**Re: I-HOP at 10860 Unser Blvd. NW
Erosion and Sediment Control Plan
Engineer's Stamp Date 1/29/24 (A11E018A)**

Based upon the information provided in your submittal received on 1/29/2024, the above-referenced ESC Plan cannot be approved for a Grading Permit or Building Permit until the following comments are addressed.

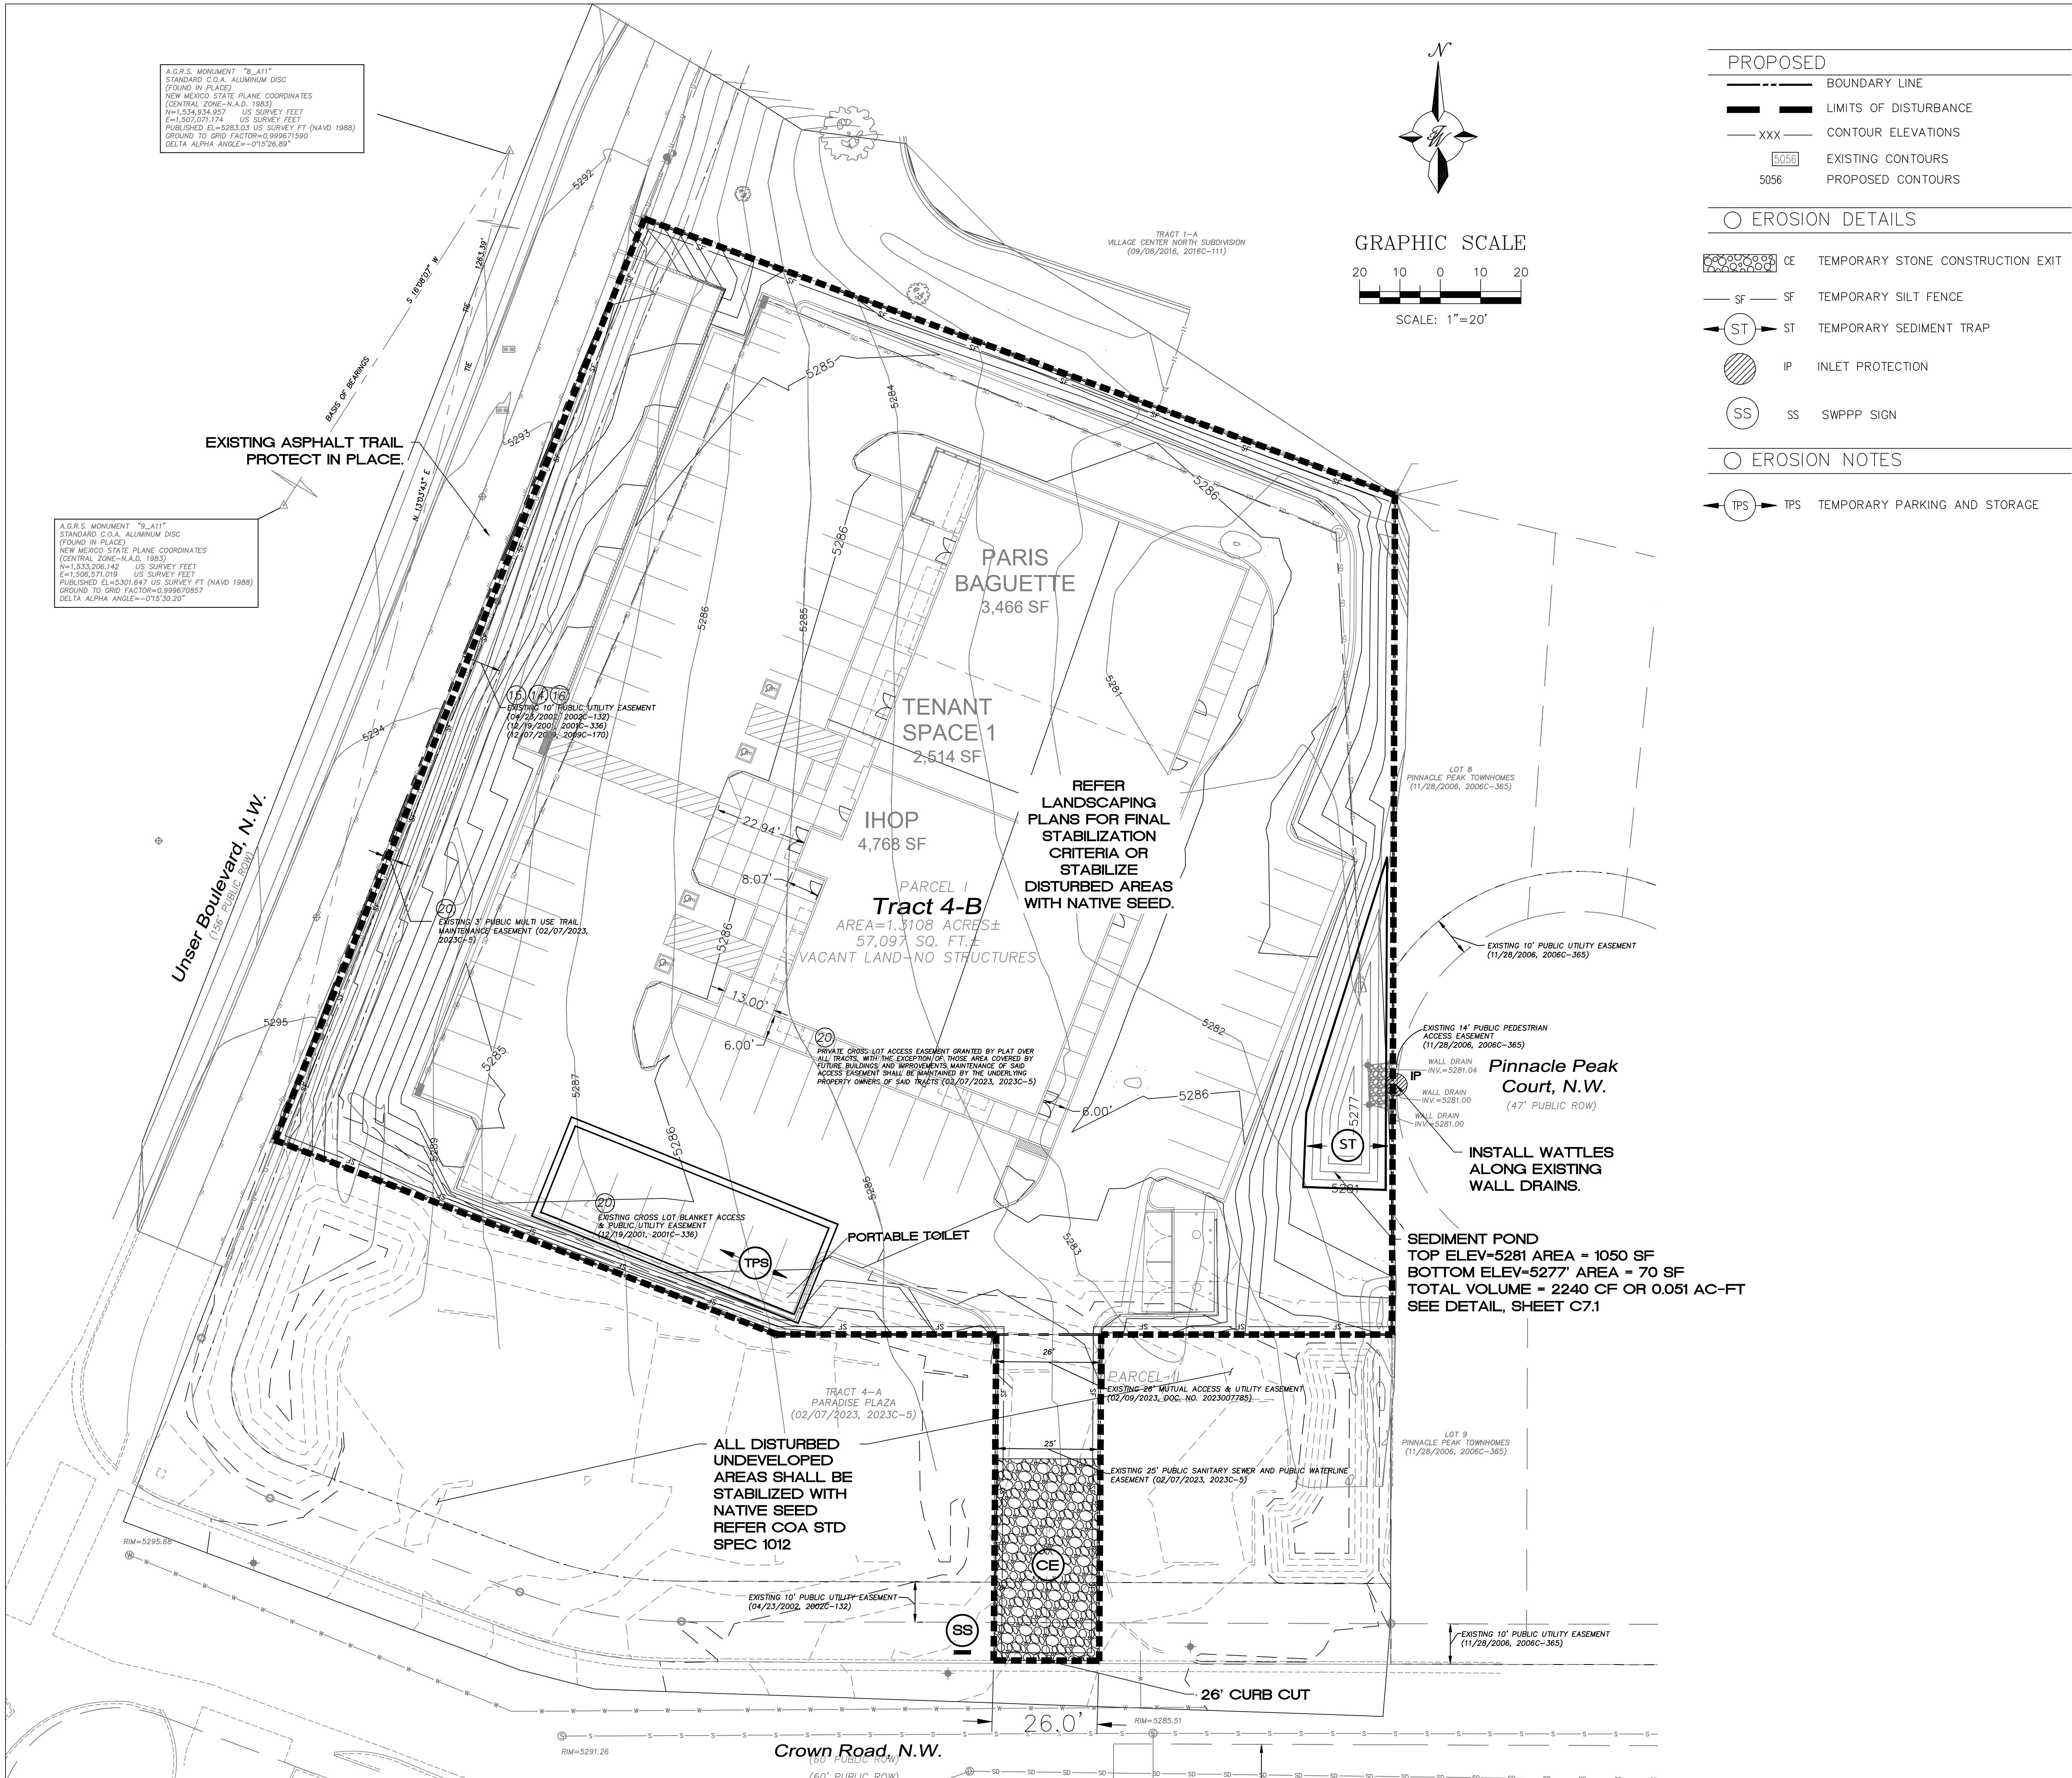
1. The owner information shown on the Information Sheet, "Unser Property LLC," doesn't match the available information from Bernalillo County tax records, "Branden Reed Properties LLC." Property rights may have changed hands recently; if so, please provide documentation in the form of a recorded deed or lease. The accurate name and contact information for the entity in control of the property rights is required on the Information Sheet, the NPDES documentation, the SWPPP, and the ESC Plan.

2. The SWPPP must include site-specific interim and permanent stabilization per CGP 9.6.1.c.i. The Landscape Plan can be used to satisfy this requirement and should be submitted separate from the ESC Plan with the application to the Stormwater Quality Section of the Planning Department, and it should be included in the SWPPP. Provide a specification on the ESC Plan for any disturbed areas not covered by the Landscape Plan or Work Order sheets.

3. Update the engineer's stamp date each time the plan changes.
